From: Judith Ward
Sent: 27 February 2023 16:22
To: Linda Griffiths
Subject: 22/03868/OUT Barwood Homes, Bloxham Road Banbury

Judith Ward
Landscape Planning Officer
Cherwell District Council

drawing title
Proposed Representative Viewpoints

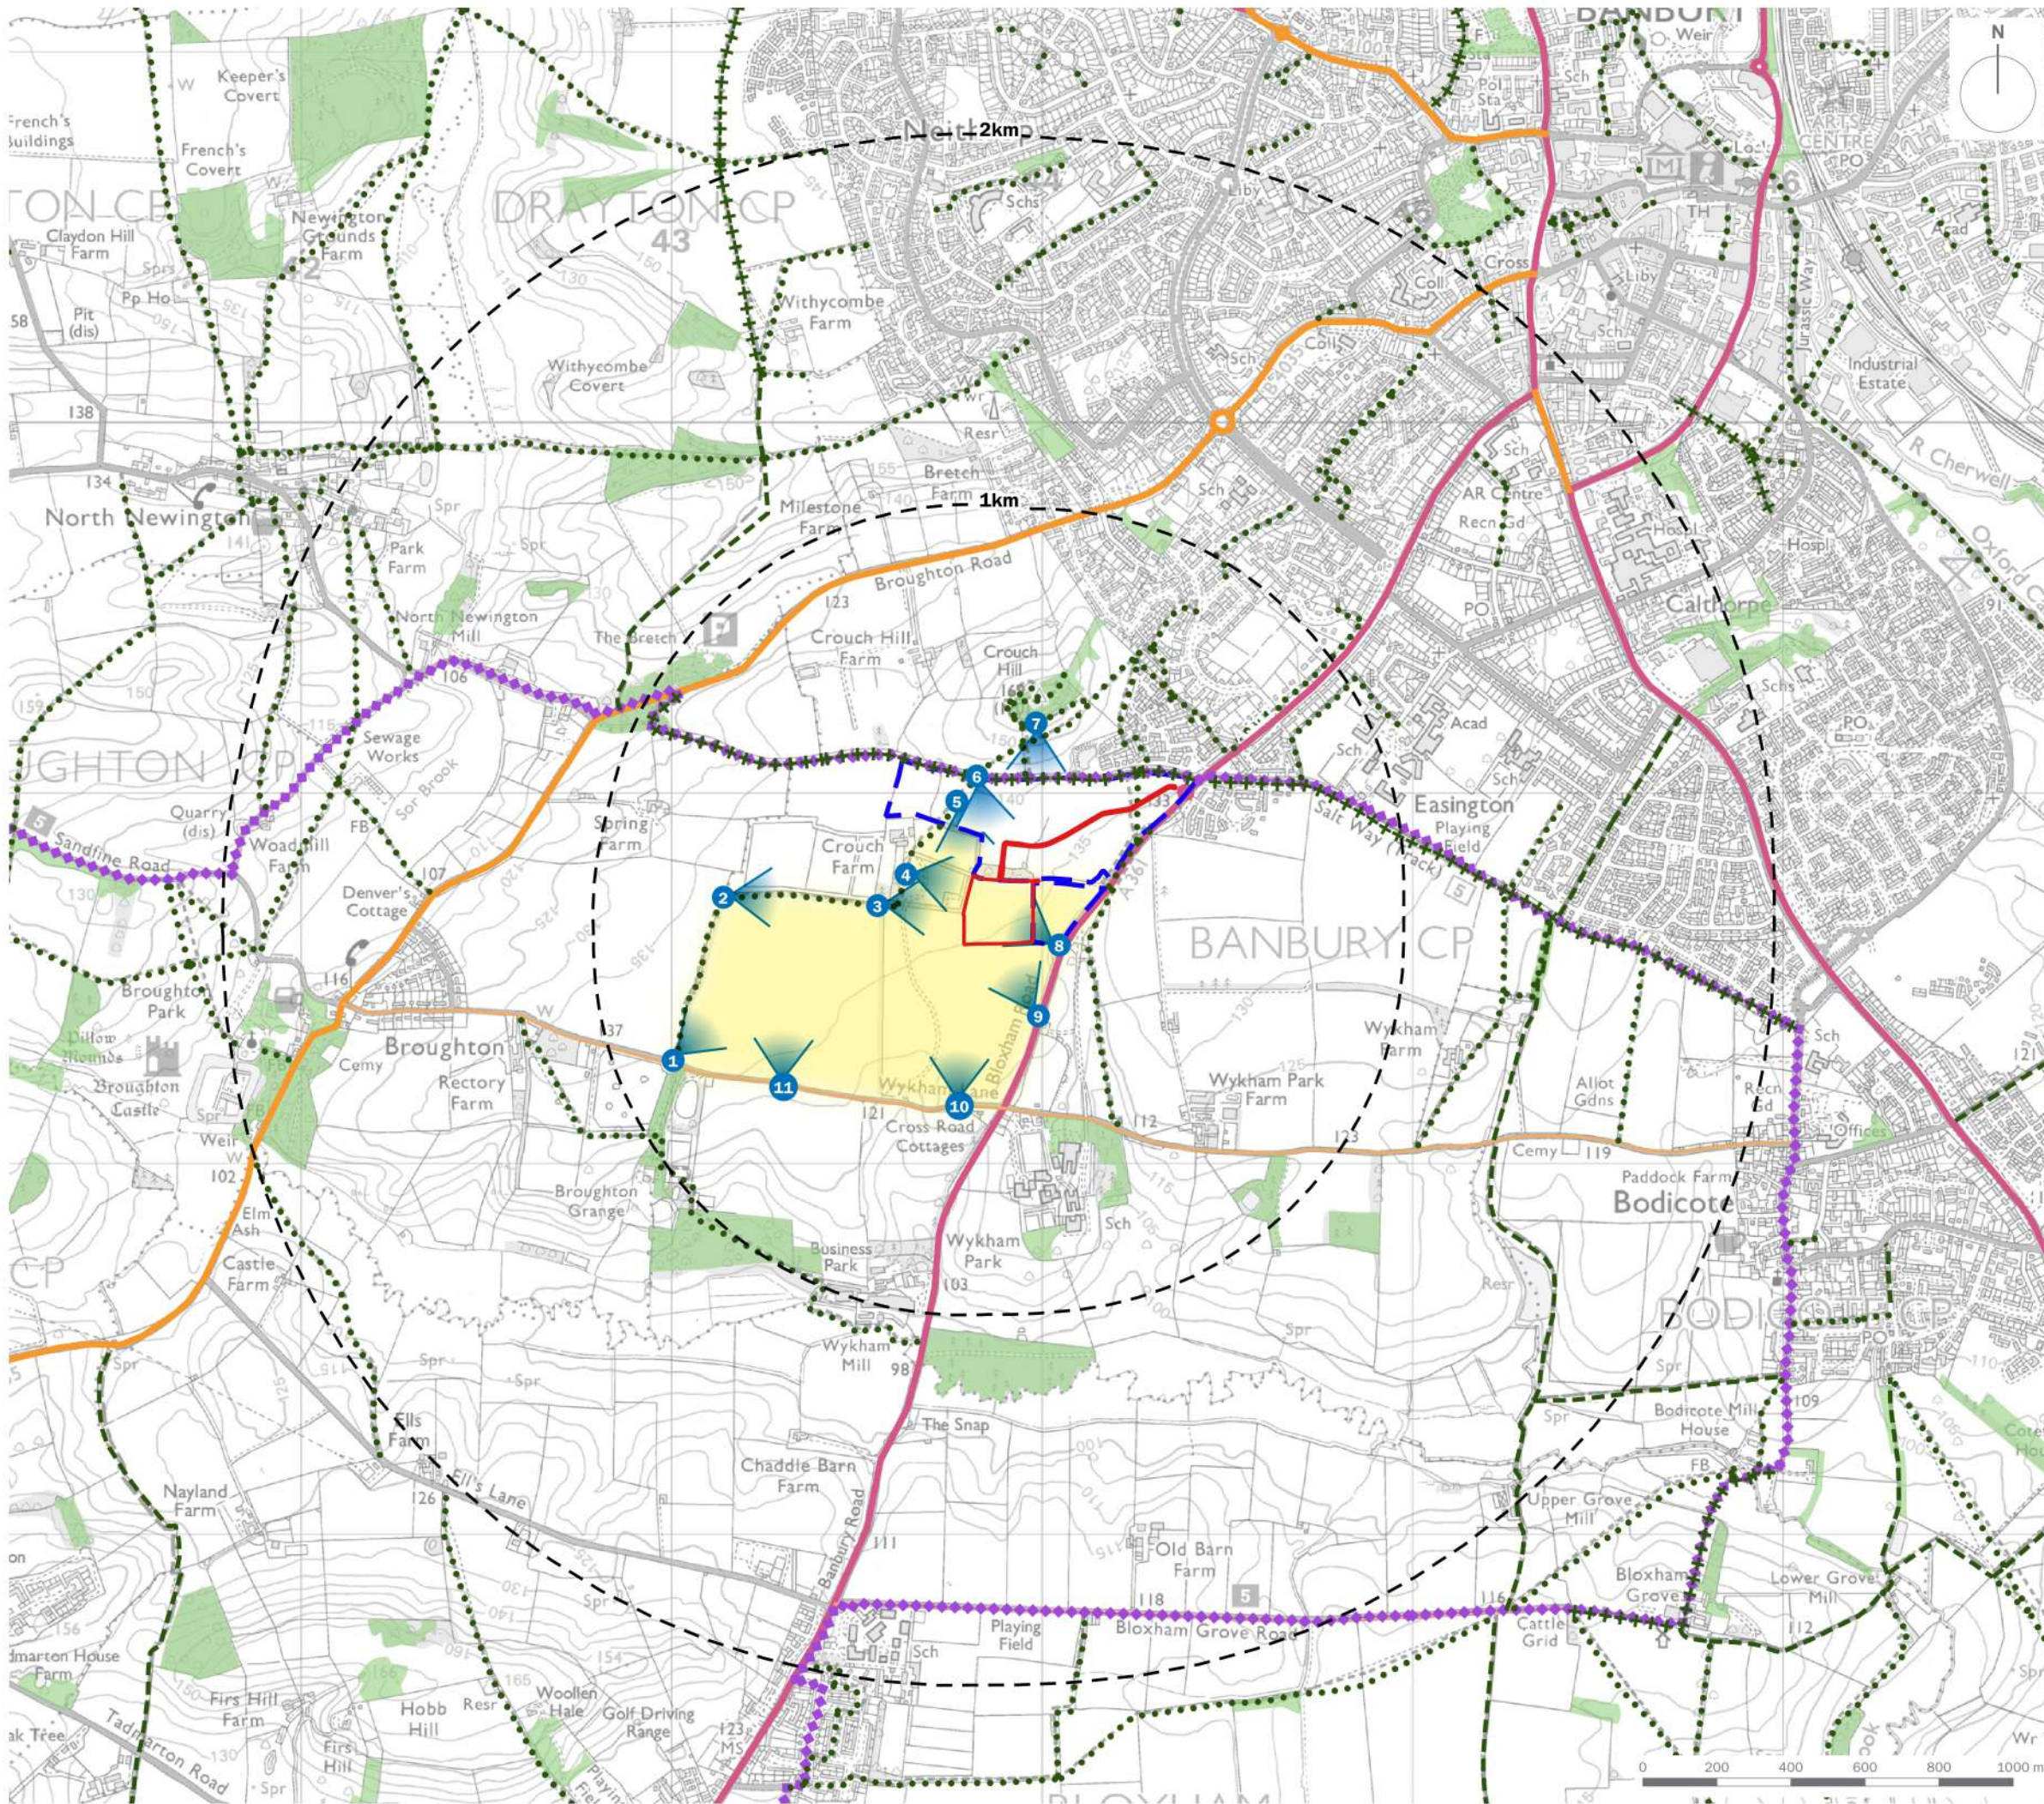
Why no ZTV ? No explanation of why only a ZPV. We need to see a ZTV to reassure ourselves that there are not wider impacts.
